From: Contact Centre (CRM) <contact@ribblevalley.gov.uk>
Sent: 06 October 2025 23:27
To: Planning
Subject: Planning Application Comments - 3/2025/0701 FS-Case-755024355

Planning Application Reference No.: 3/2025/0701

Address of Development: 33 Castle St, Clitheroe

Proposed front elevation

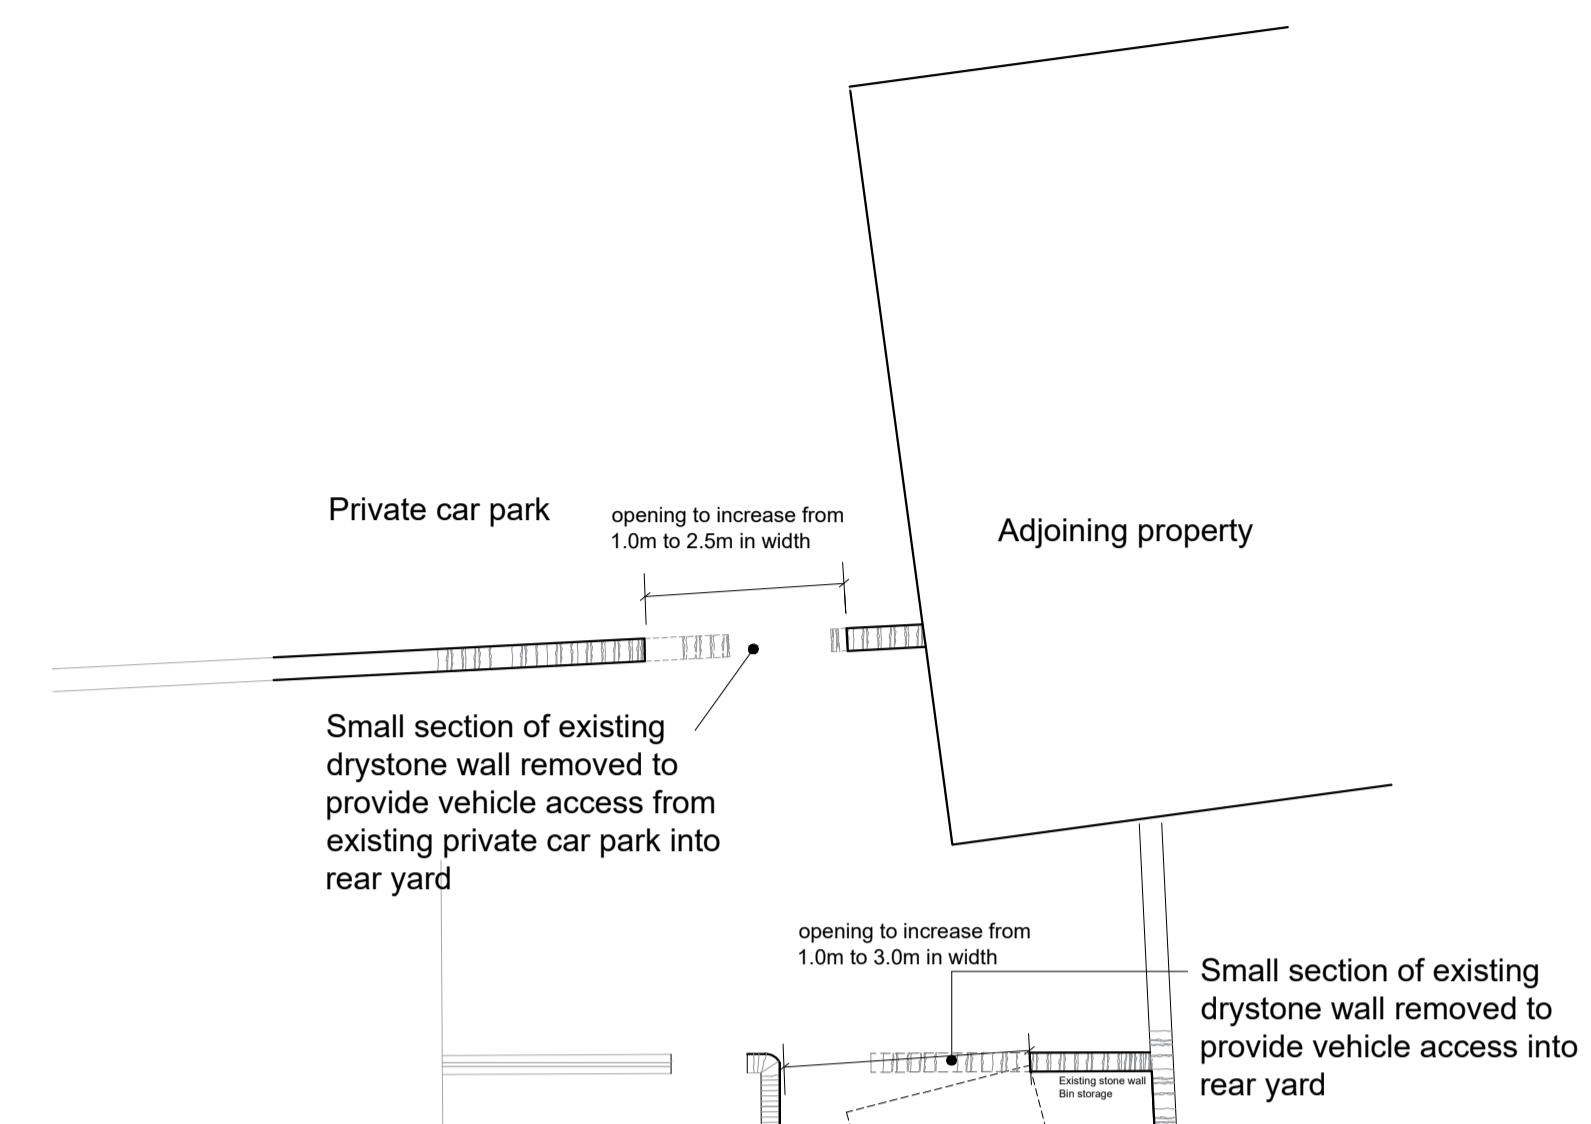
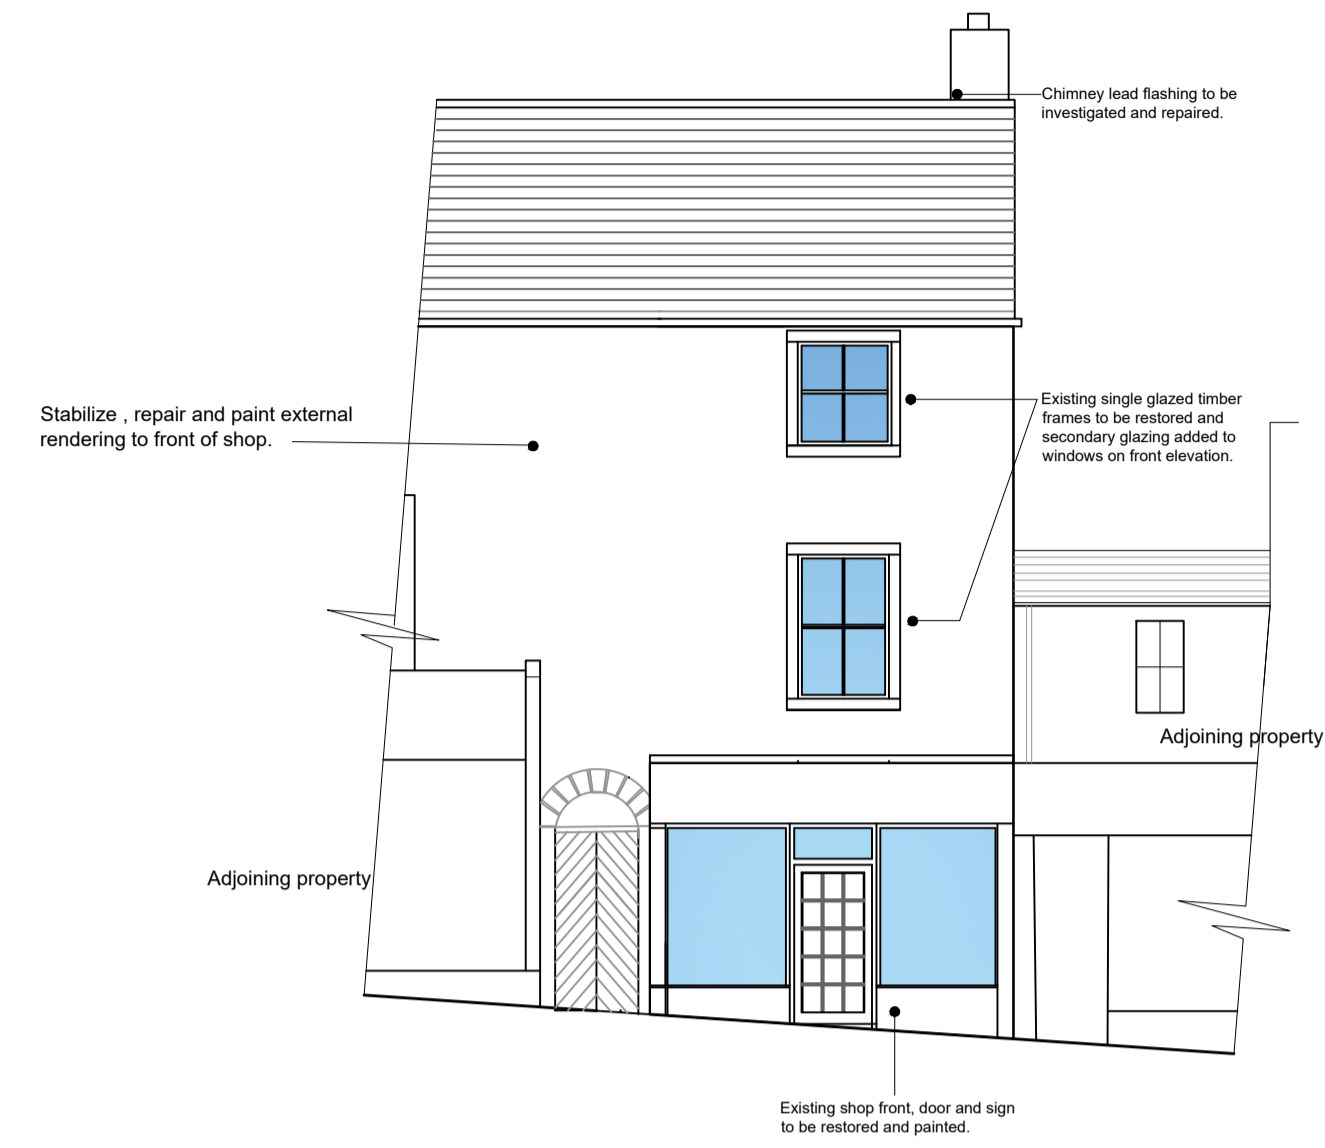
The plans say 'Carefully repair and paint existing shop front and sign board', but there is no further detail on this other than it will be painted white. Referring to the Conservation Area Management Guidance with regard to painting exterior of buildings in the CA, and treatment of shop fronts we would point out that the ashlar scoring on the render is an important feature so any repairs to the render will need to be careful to imitate this. Also the type of paint is important, ie breathable paint is best and will avoid it blowing and flaking like the existing plastic paint has done.

Comments: I submit comments on behalf of [REDACTED] in respect of 33 Castle St. The plans are sensitive to the historic features of the building and there will be minimal interventions to historic fabric. The harm caused by the creation of a new door in the back wall is justifiable, as the benefits of introducing this mean the building can operate as a shop and flats. The main priority with this building is to have it occupied, so it has a sustainable future.
